MY PLACE EXTENDED STAY
 3 STORY - 64 GUESTROOM PROTOTYPE
 PROJECT:

SITE PHOTOMETRICS
 PROJECT #
 E100P
 SHEET #

Markup Summary

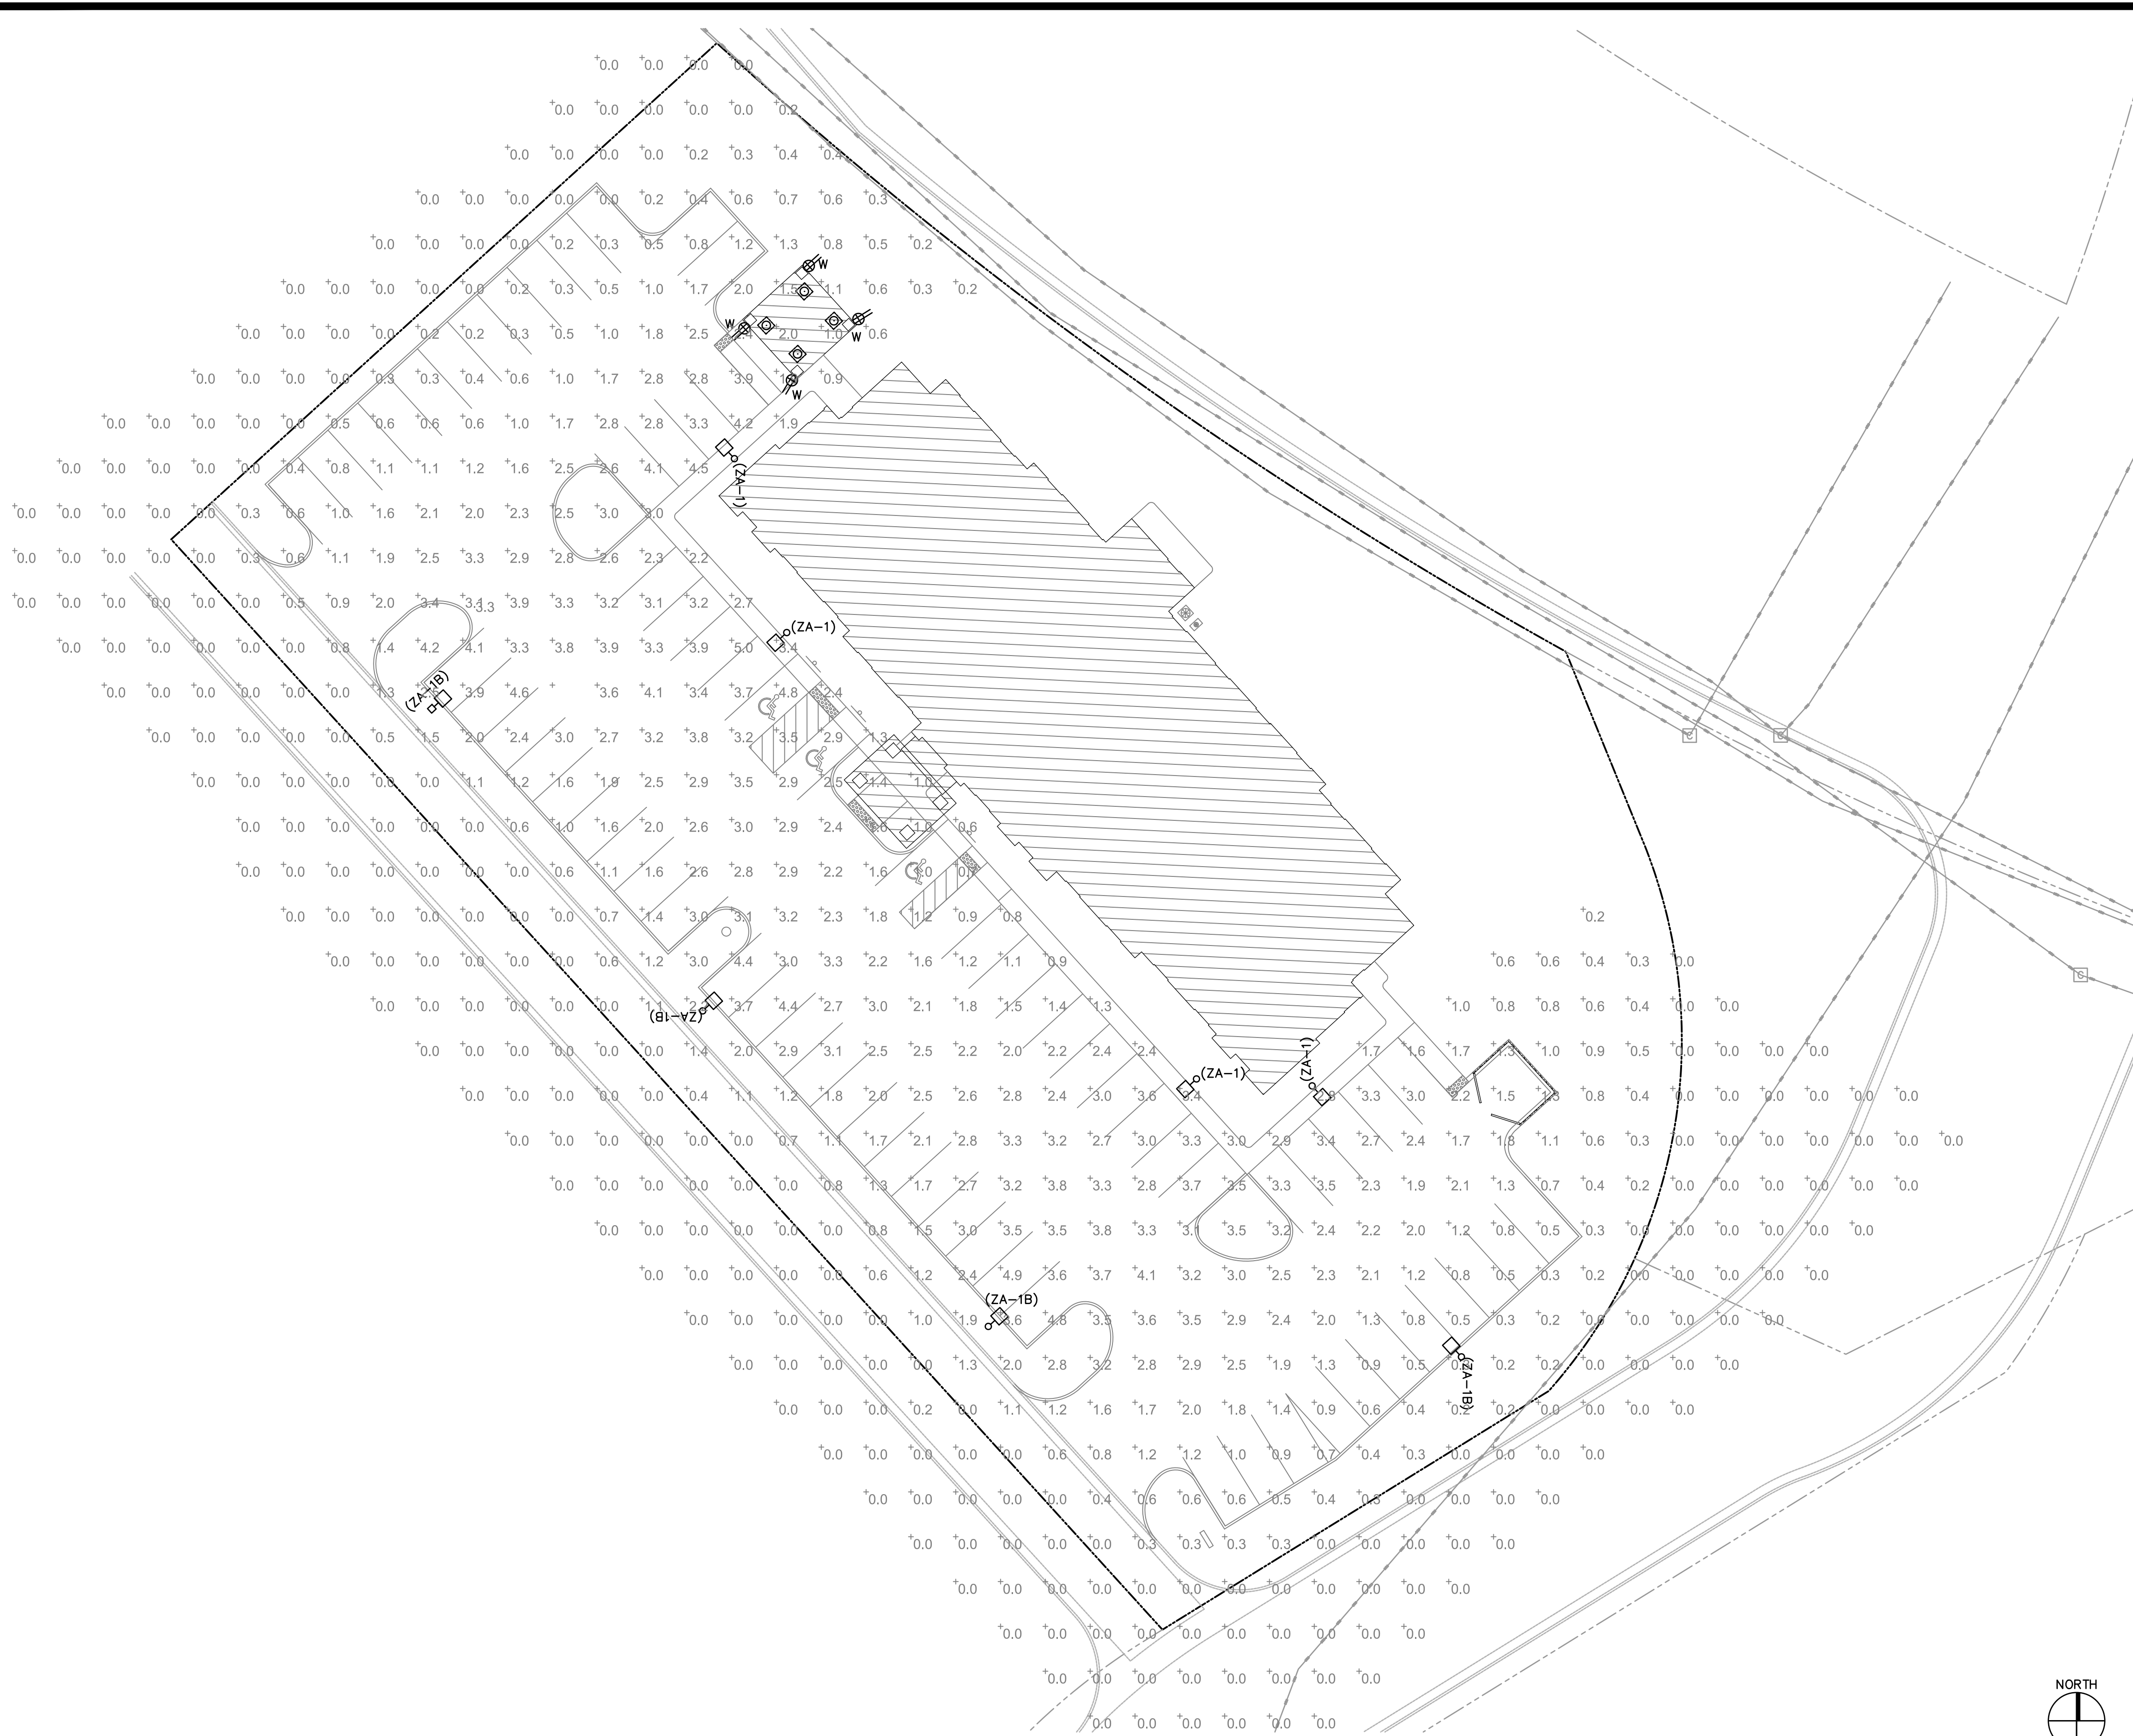
The lighting exceeds 0 at the property line. Please place or lower the lighting to meet the Code Section 6.2.3 pg. 6-17.
